**OXFORDSHIRE COUNTY COUNCIL’S RESPONSE TO CONSULTATION
ON THE FOLLOWING DEVELOPMENT PROPOSAL**

Application no: 21/03267/OUT

Proposal: Outline planning permission (all matters reserved except for access) for the erection of buildings comprising logistics (Use Class B8) and ancillary Office (Use Class E(g)(i)) floorspace and associated infrastructure; construction of new site access from the B4100; creation of internal roads and access routes; and hard and soft landscaping

Response Date: 8th December 2022

JOB TITLE		M40 JUNCTION 10		CLIENT		ALBION LAND	
DRAWING TITLE							
EASTERN ACCESS GENERAL ARRANGEMENT PRE-GROWTH FUND SCHEME							
SCALE	DRAWN BY	DATE	DRAWING No	REVISION			
1:500@A1	RM	03/08/21	17213-16-GA	P0

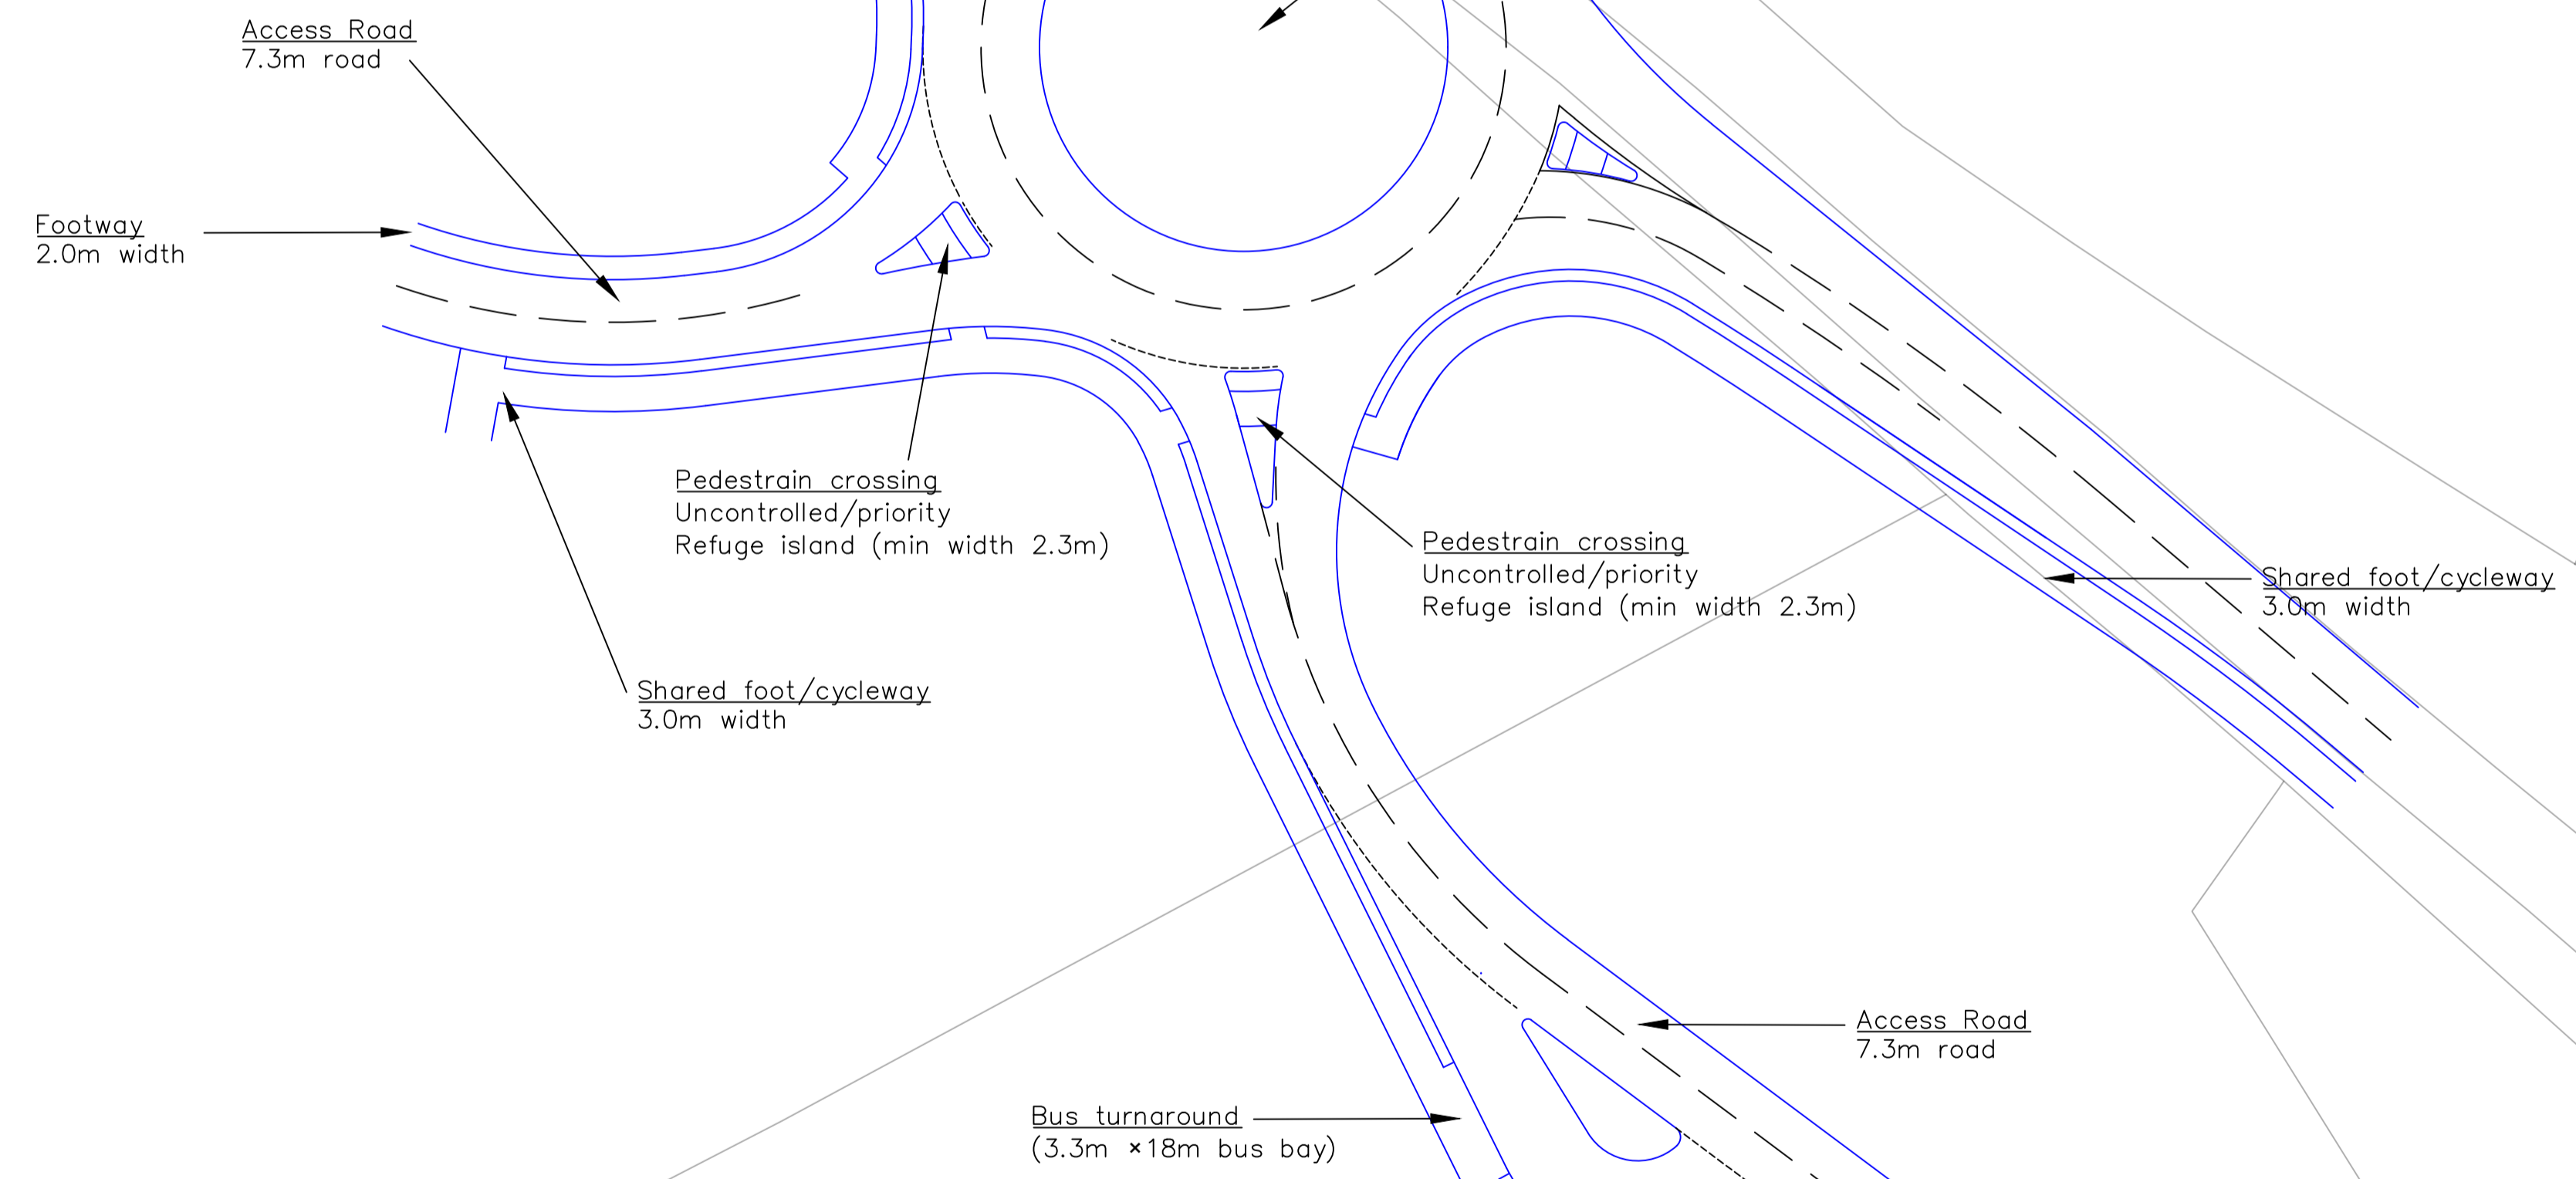
- The footway/cycleway appears to go outside the highway boundary on the B4100 western arm:

- This will need to be addressed in the design, as the footway cycleway link is necessary to make the development acceptable and to provide safe access to the western site.
- Where land allows, the footway/cycleway should have a greater separation from the carriageway.
- The scheme would require land within the site to be dedicated as highway.
- A drawing should be provided showing the proposed scheme alongside the development access roundabout, so that we can see the interrelationship between the two.
- It isn't clear whether the developer would intend to deliver the scheme under a S278 agreement – this should be clarified.
- I am concerned that the split into three lands on the northbound approach to the roundabout looks quite short, especially given the position of the crossing.
